Consultation Response from Mark Berry KC, Highways Development Management		
2021/91638 Land at Hart Street, Newsome, Huddersfield, HD4 6LS		
Reserved matters application pursuant to outline application no. 2016/91479 (appeal no. APP/Z4718/W/17/3173711) for erection of 22 dwellings		
Date Responded: 17-08-2021	Responding Officer: Mark Berry	Responding Ref: 6-8NE-12

This is a reserved matters application pursuant to outline application number 2016/91479 (appeal no. APP/Z4718/W/17/3173711) for the erection of 22 dwellings at land at Hart Street, Newsome, Huddersfield.

Dwg No: 571/07(02)015 A

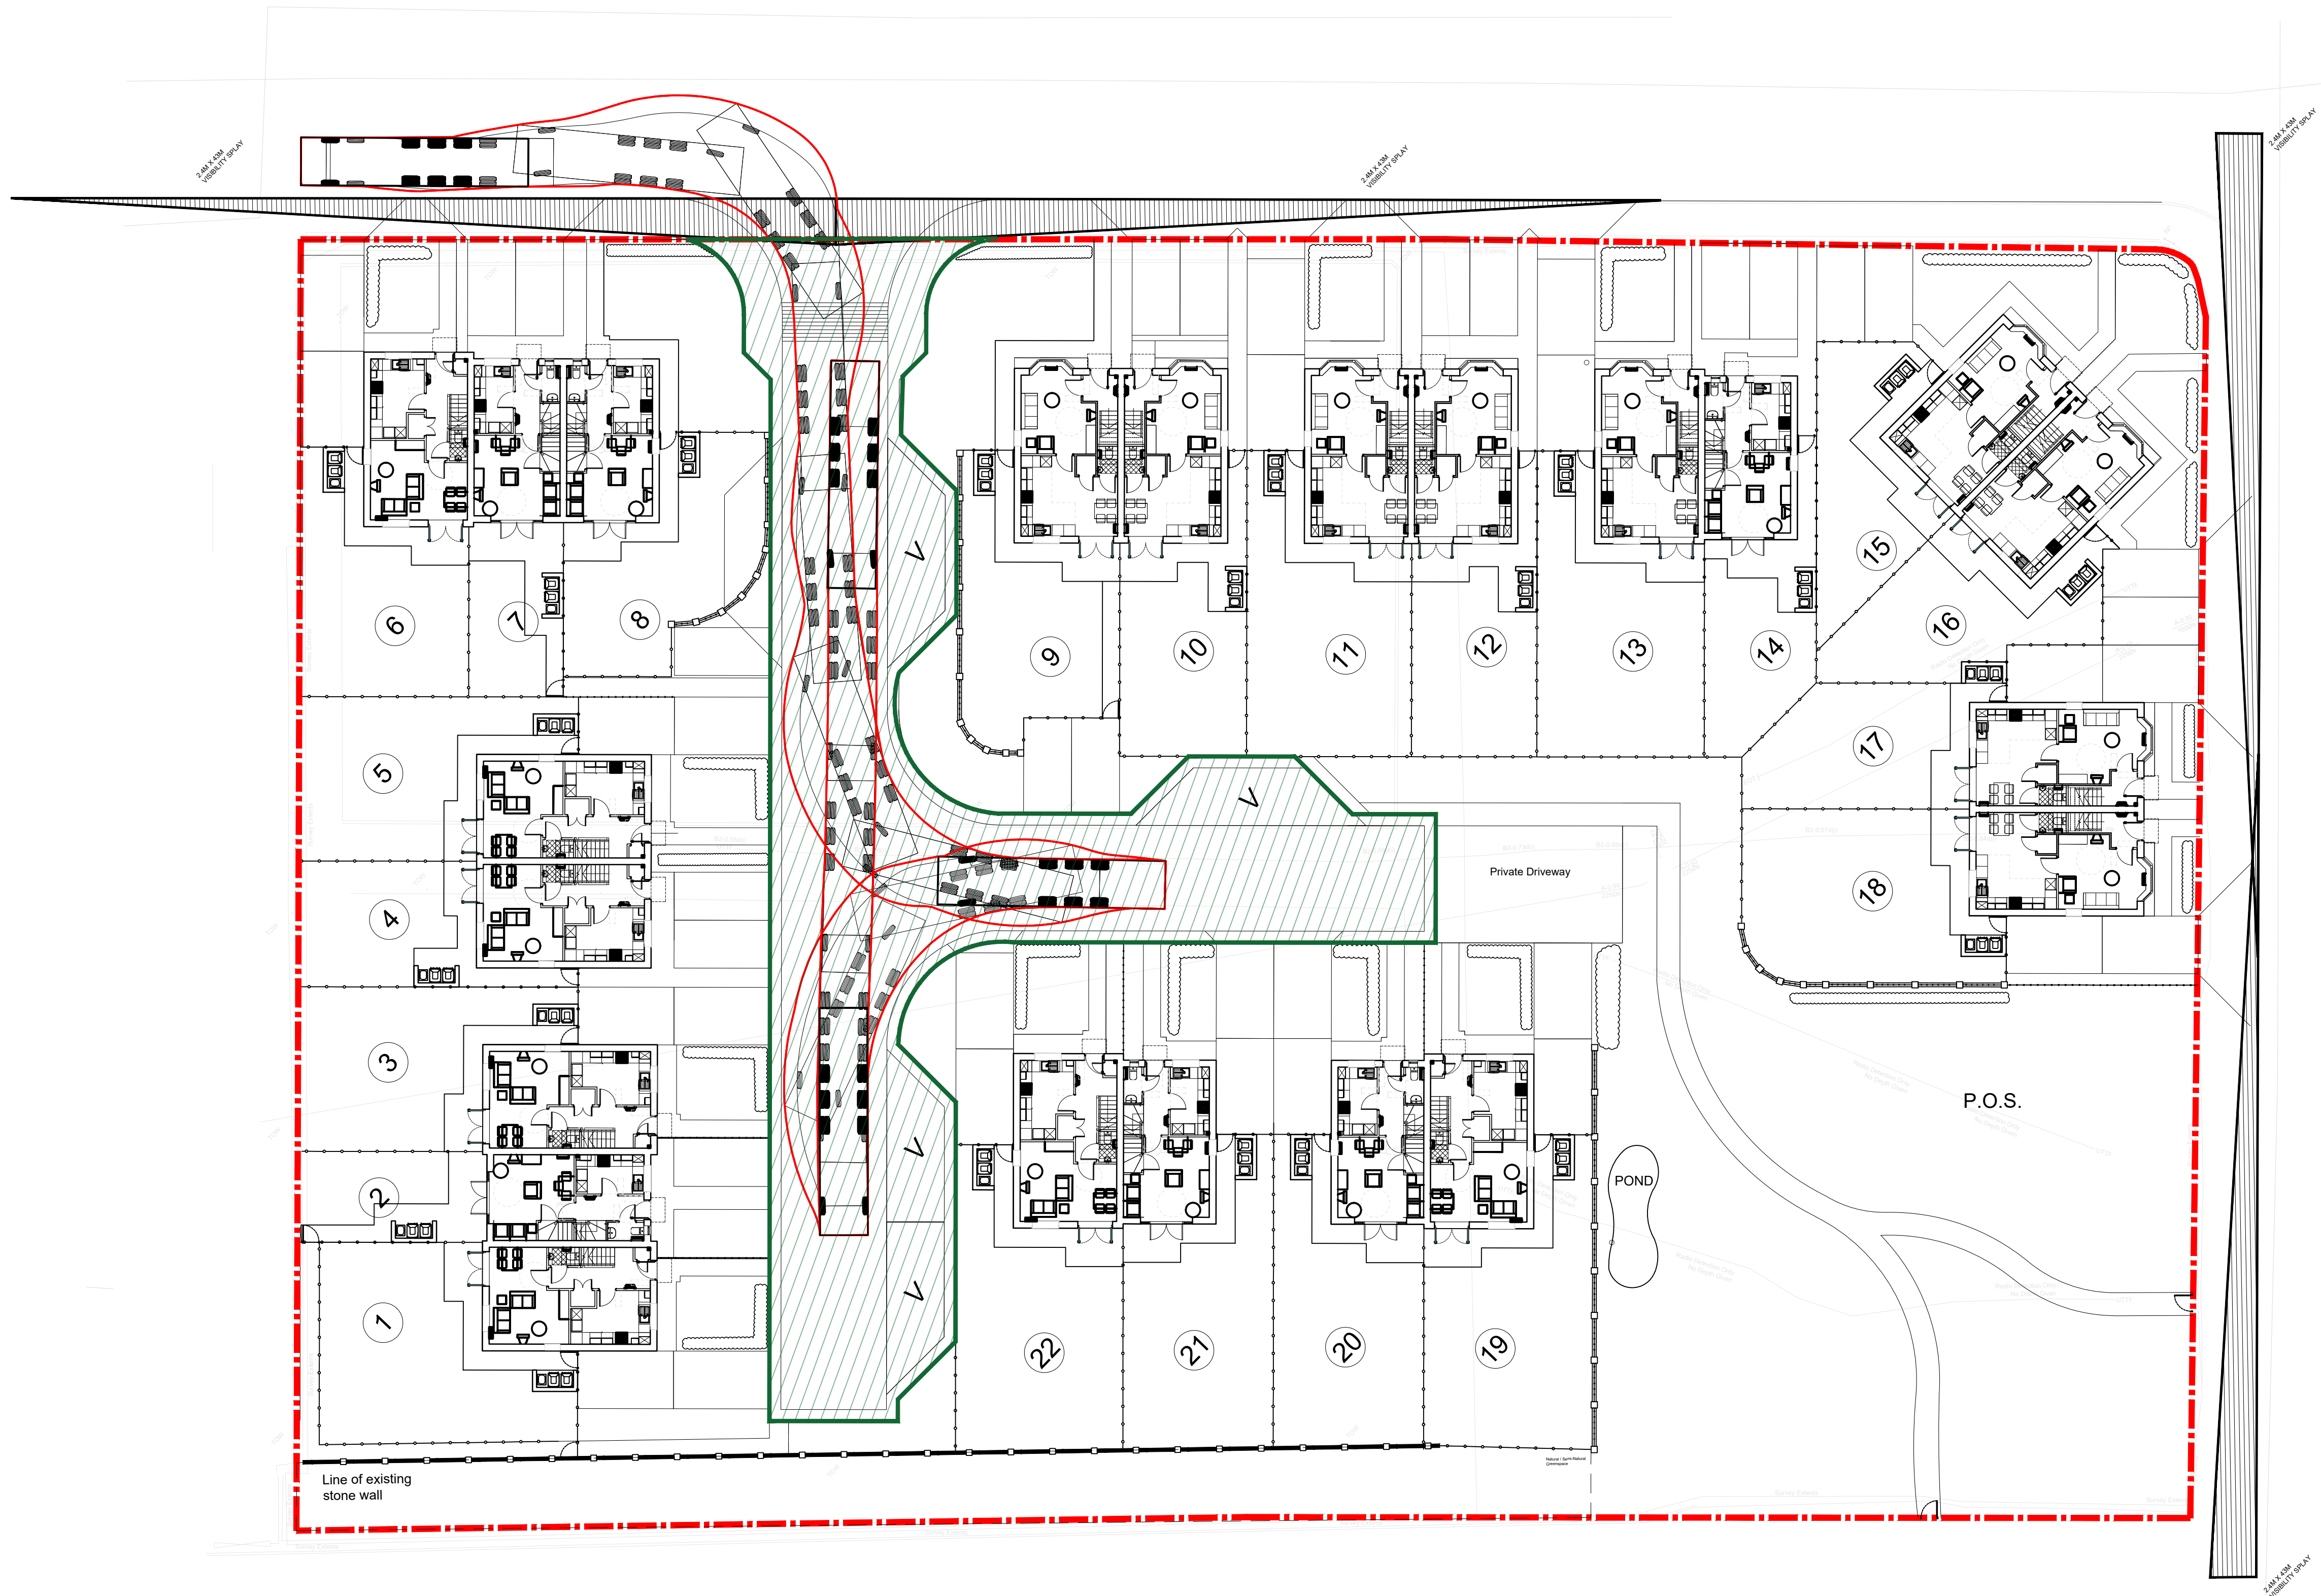
- 1, Direct frontage access onto Newsome Road should be avoided. Newsome Road is heavily trafficked, and this is not recommended.
- 2, Swept paths should be provided for an 11.85 m refuse vehicle.
- 3, 2.4 x 43m visibility splays should be shown from the site access onto Hart Street.
- 4, Plot numbers 2,13 to 15,19 to 21 have insufficient off-street parking.
- 5, Sight lines at the junction of Hart Street and Newsome Road and Naomi Street and Newsome Road should be shown not to be compromised by these proposals.
- 6, It's not clear from the proposals which areas of the internal access road are intended for adoption.
- 7, Bin collection points should be provided to all dwellings.
- 8, Visitor parking should be provided at the rate of 1 space per 4 dwellings.
- 9, The parking spaces to plot 7 are located on the Hart Street junction radii .

The applicants have provided Proposed Highways Plan number 571/07(02)015 and Proposed Bin Collection Plan number 571/07(02)014 which address all the above points other than points 1 and 9.
